Please ask for: Ms Iqraa Malik
Email: iqraa.malik@terraquest.co.uk
Telephone: 01212341390
Our Ref: LU/312/20/HH
Your Ref:
Date: 26th November 2020

Application for Planning Permission for Works or Extension to a Dwelling

Development: To convert a section of the existing garage to create a annex for occasional self contained assisted living for an elderly relative to convalesce and occasional holiday accommodation for guests.
One place will be retained in the garage for car parking, this is adequate for my needs, the elderly relative who wishes to stay in the Annex is unable to drive and increasingly unable to manage the stairs to the upper floors. There is also "pay and display" parking locally for other guests.
The Ground floor is designed as sacrificial in the event of rising sea levels and flooding from the nearby River, at the time of construction this seemed acceptable but unexpectedly I find I now need to accommodate relatives with increasing Disabilities .

Location: 18 River Road Littlehampton BN17 5BN

1:1250
18 River Rd
L. Hiehang for

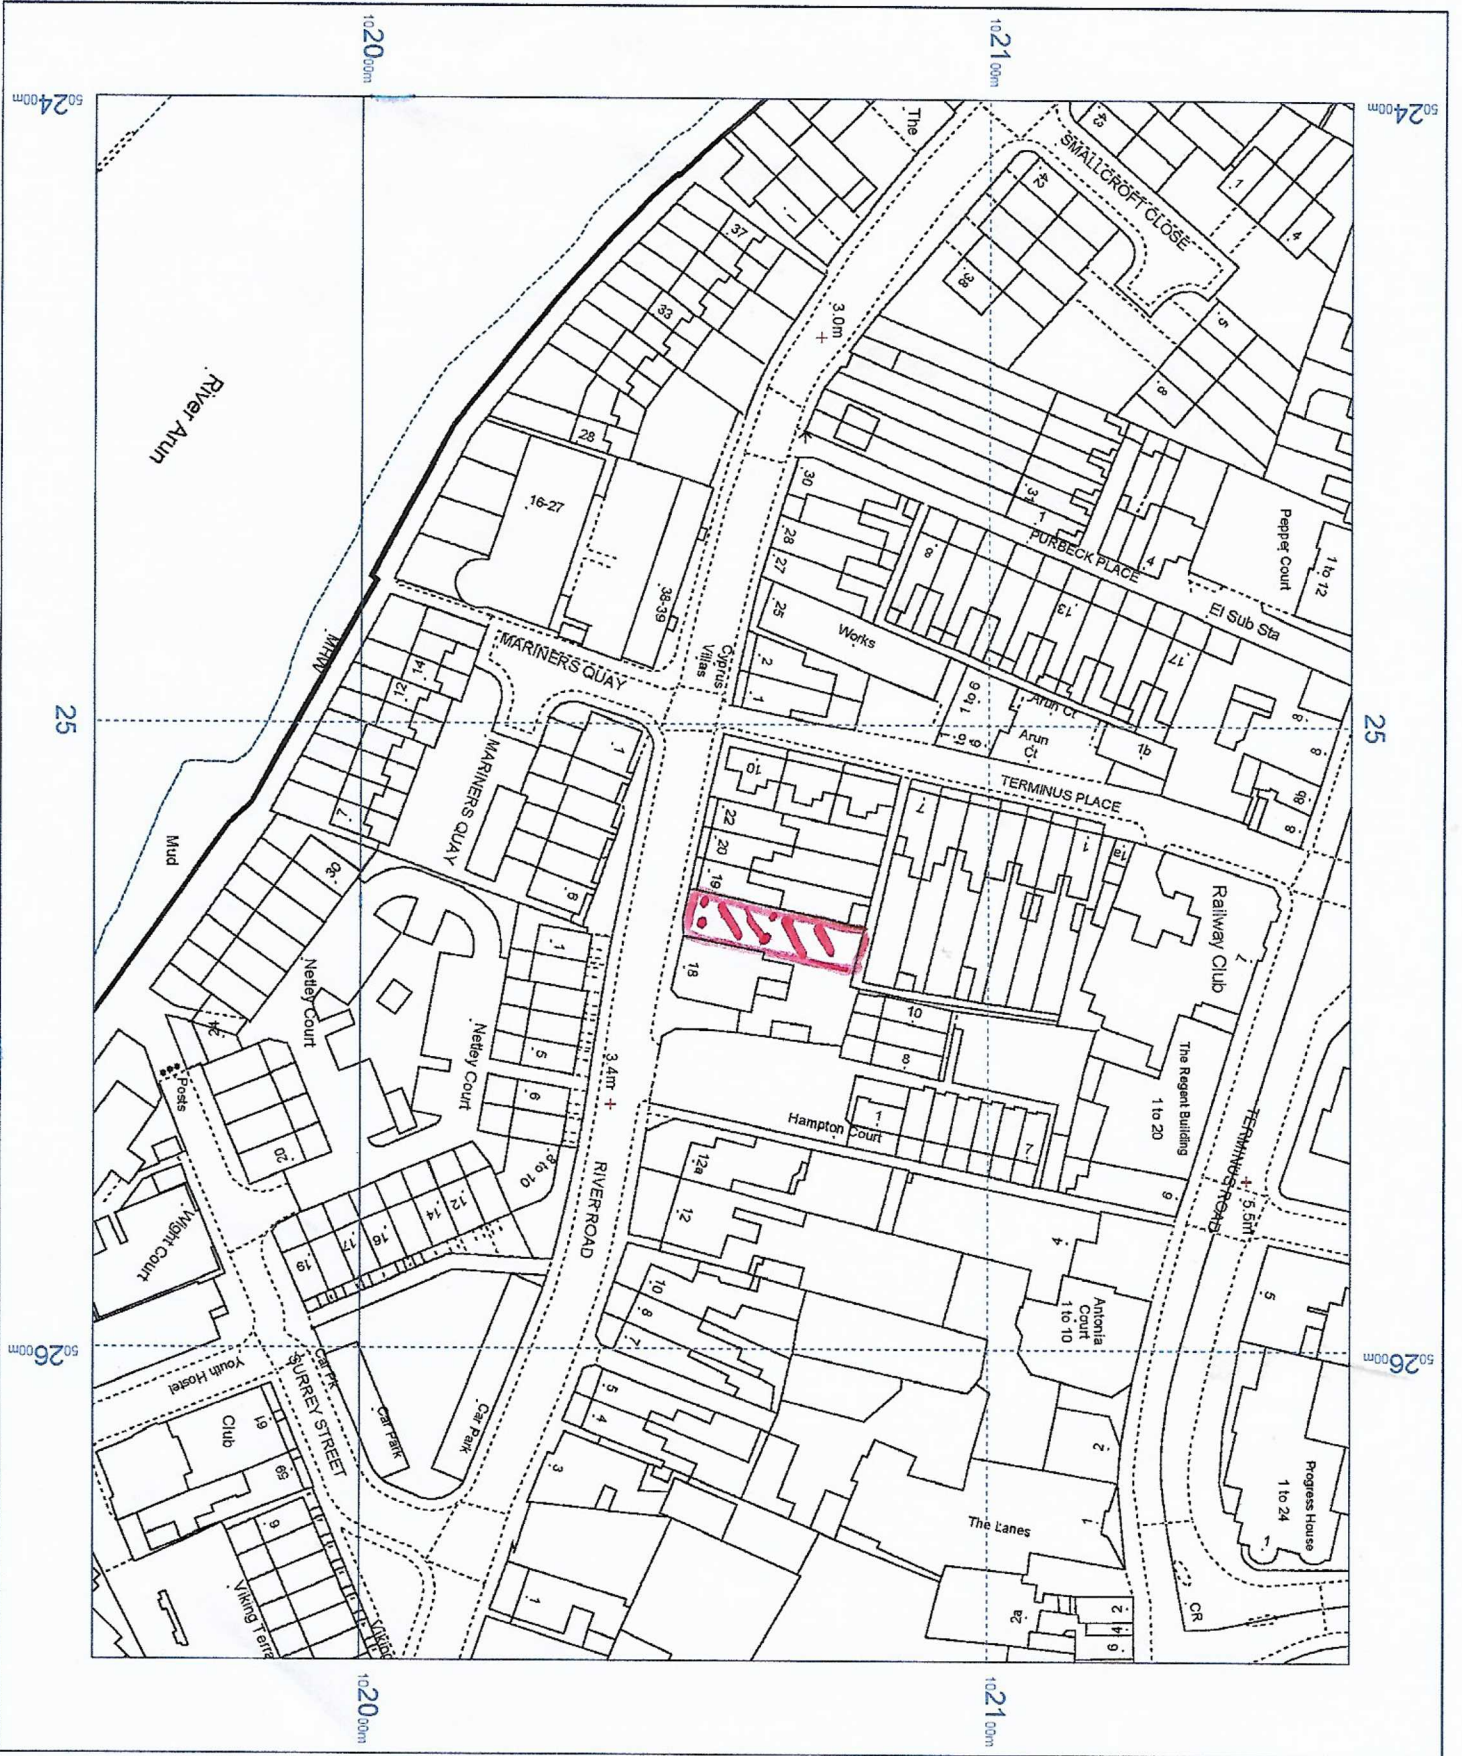
You are required to have a solid red around the site on the location and block plan. Please amend

proposed ground floor plan:
No change to elevations:

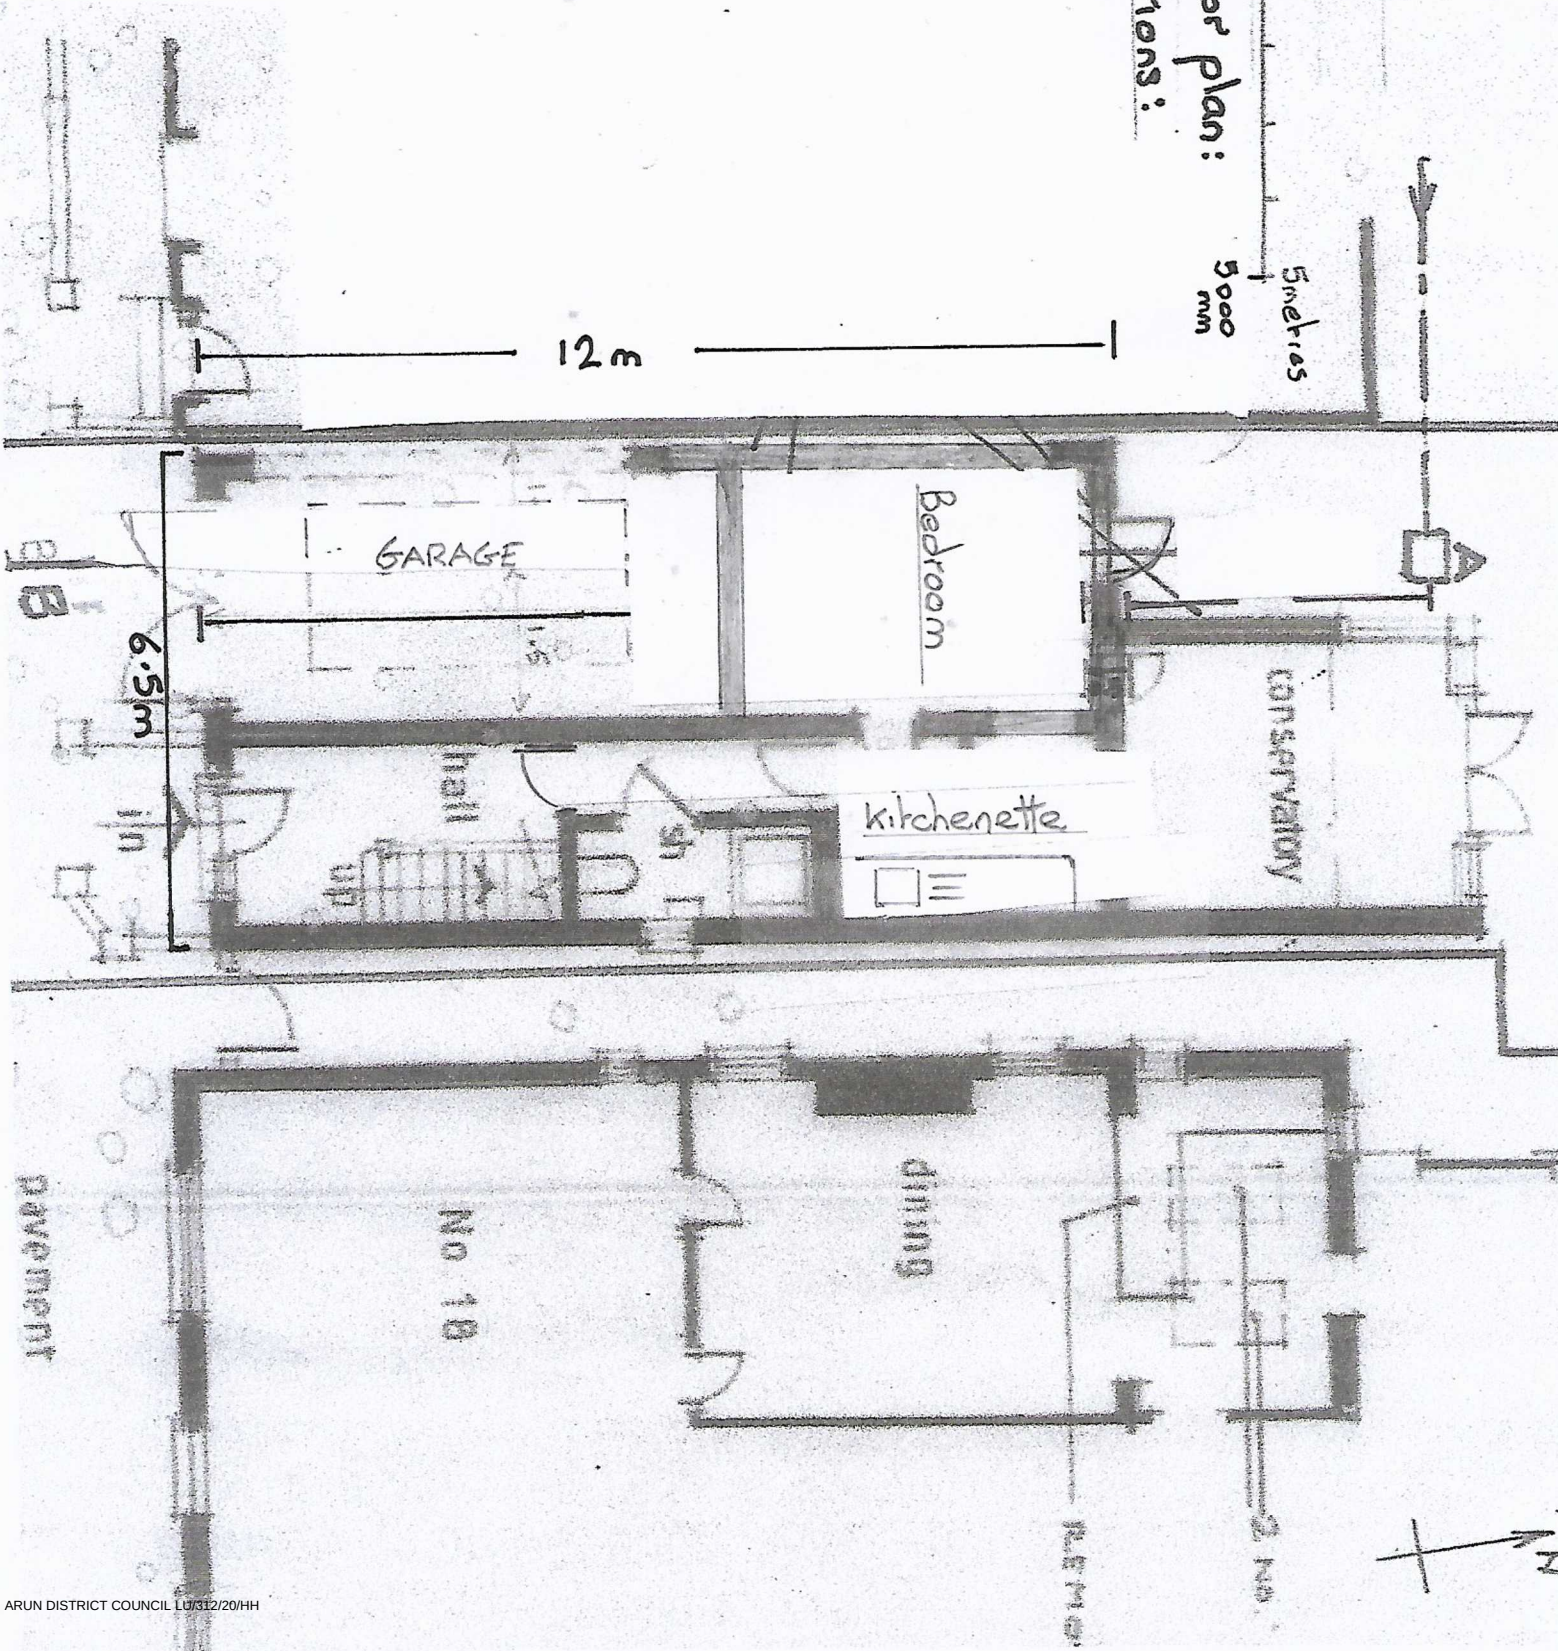
Room Label: Please add a room label to the proposed plans

Existing Plans: The existing floor plan cannot be a screenshot from a website. Please amend

Elevations: Please confirm whether the elevations are changing. If so scaled elevations are required.

Scale Bars: You are required to have scale bars on all plans
